Appeal against the Application for Planning Permission for Works or Extension to a Dwelling. Reference AB/10/15/HH

1. The application submitted by Mr. and Mrs. A Lugton of 4 Orchard Place, Arundel for the retention of a timber "shed" is challenged on a number of counts.

rear elevation

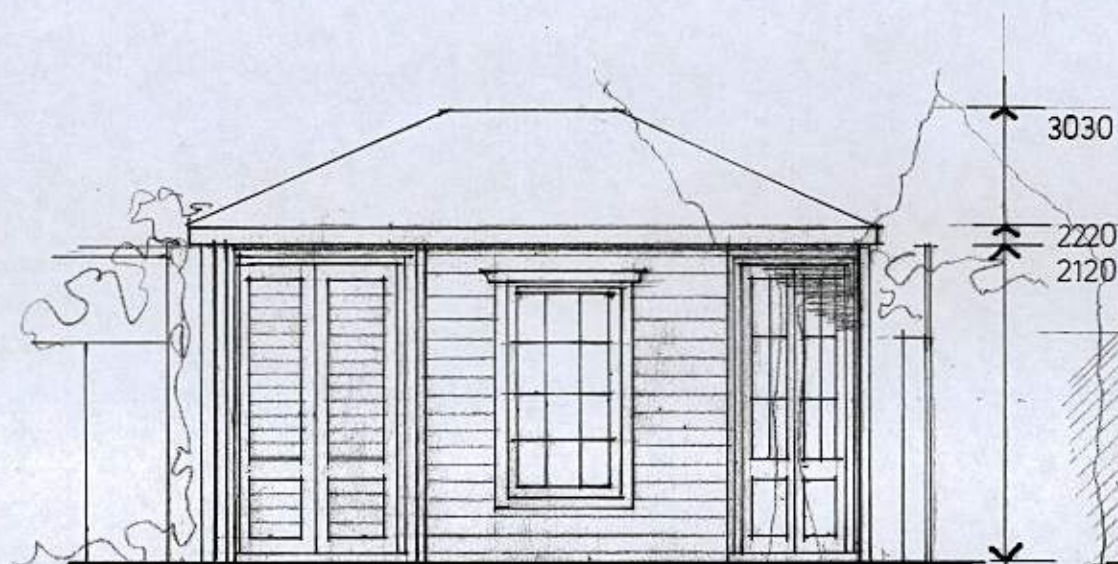
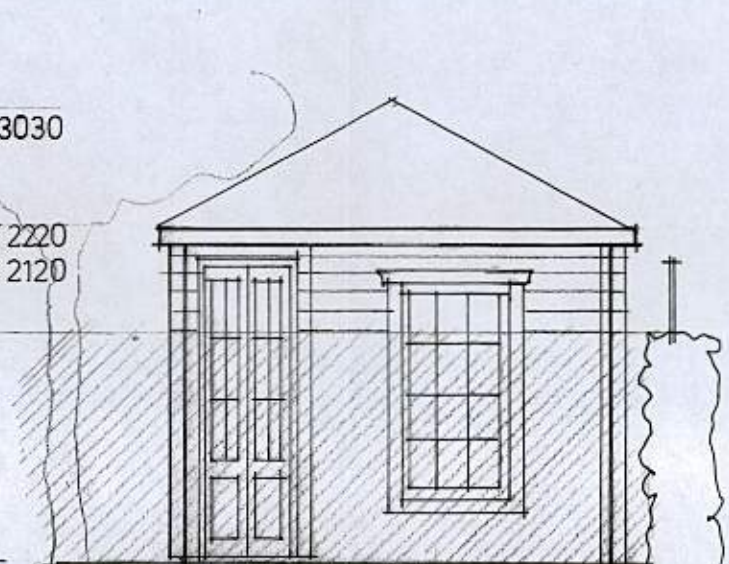
- b. The area footprint for such a cabin is 2.8m x 4.2m that is 11.76m, exceeding the allowable 10 square metres.
 - c. The permitted maximum height should not exceed 2.5m, including all coverings, in a conservation area. Additionally, it should not exceed 2.5m when sited within 2 metres of a property boundary. This latter requirement impinges on the properties at 2 Orchard Place, 6 Orchard Place, 1 Parsons Hill, 3 Parsons Hill and 5 Parsons Hill. The design ridge height of the log cabin is shown as 3.03

metres; additionally it sits on a base, which constitutes a raised platform.
